WELWYN HATFIELD COUNCIL
PLANNING CONTROL COMMITTEE – 28 AUGUST 2008
REPORT OF THE CHIEF PLANNING AND ENVIRONMENTAL HEALTH OFFICER

S6/2008/0690/FP

ST AUDREY'S CAR PARK, CHURCH LANE, HATFIELD, AL9 5NB

IMPROVED ENTRANCE TO HATFIELD PARK FOR COACHES AND HGV'S,
WIDENING THE ACCESS FROM CHURCH LANE, FORMATION OF COACH
PARKING AREA, CIRCULATION TRACKWAY AND ALL ANCILLARY WORKS

CLIENT:	THE CASPIAN CENTRAL ENTRIES
JOB:	ST AUDREY'S ENTRANCE
DATE:	MAR 2008
SCALE:	1:500
DRAWING TITLE:	PROPOSED SITE PLAN
DRAWING NUMBER:	757-002 E

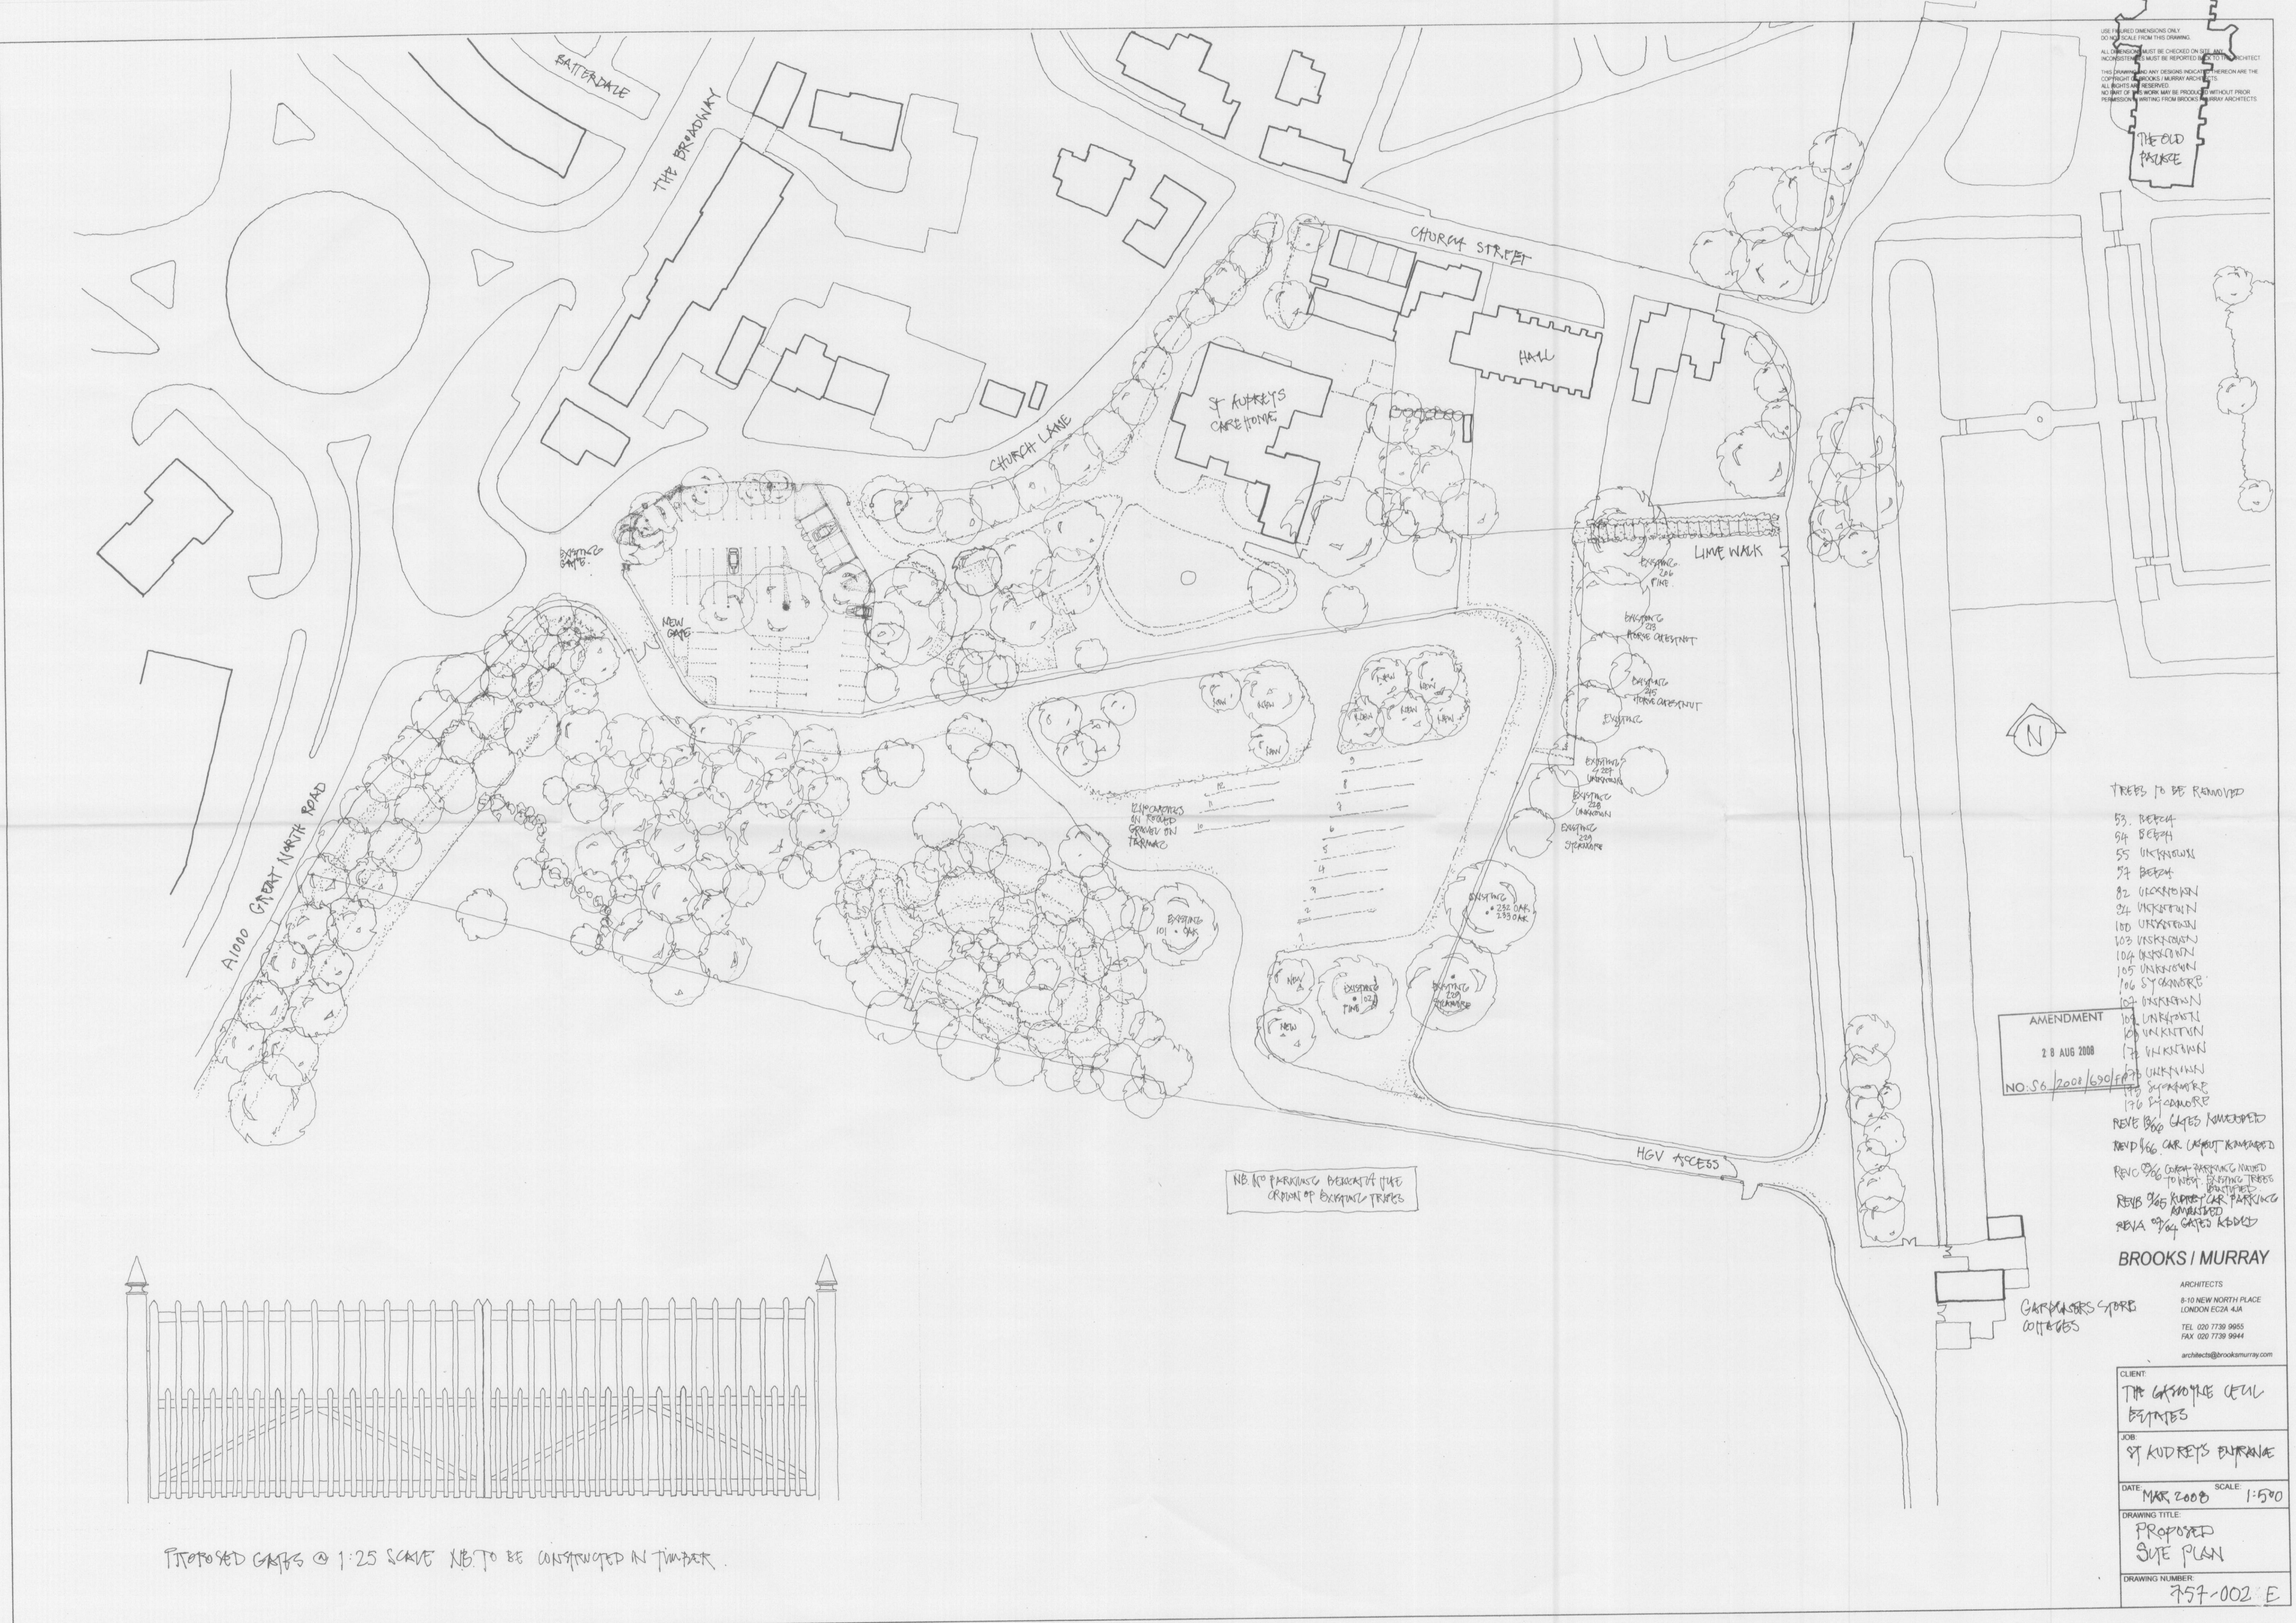
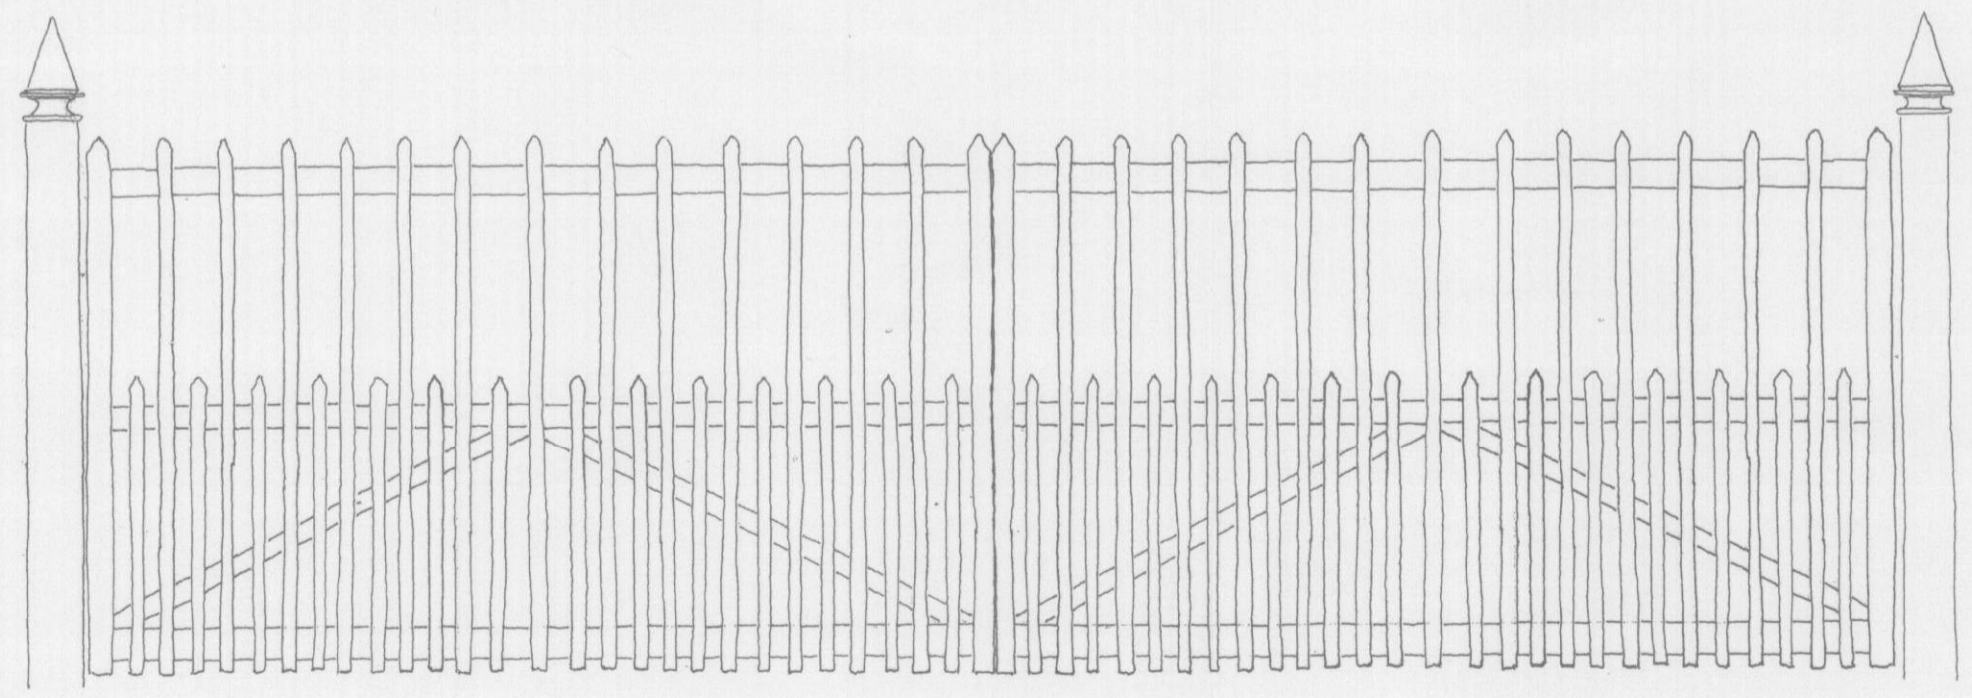
- 5.5 The new layout has been negotiated which is more sympathetic to the trees on the site with hardstandings a reasonable distance from the trees with no parking beneath the crowns of existing trees.

4. Prior to the commencement of the development hereby permitted, details of the materials proposed for the gated entrance shall be submitted to the Local Planning Authority for approval in writing. The approved details shall subsequently be implemented in accordance with the approved details. For clarification the gate is approved at a scale of 1:25 as shown on the plan submitted 17th June 2008 and not as shown on drawing 757-002D.

18. Between the hours of 2130 and midnight coaches shall be parked in spaces labelled 1 – 4 as shown on drawing number 757-002D dated 17 June 2008 and in no other part of the site.
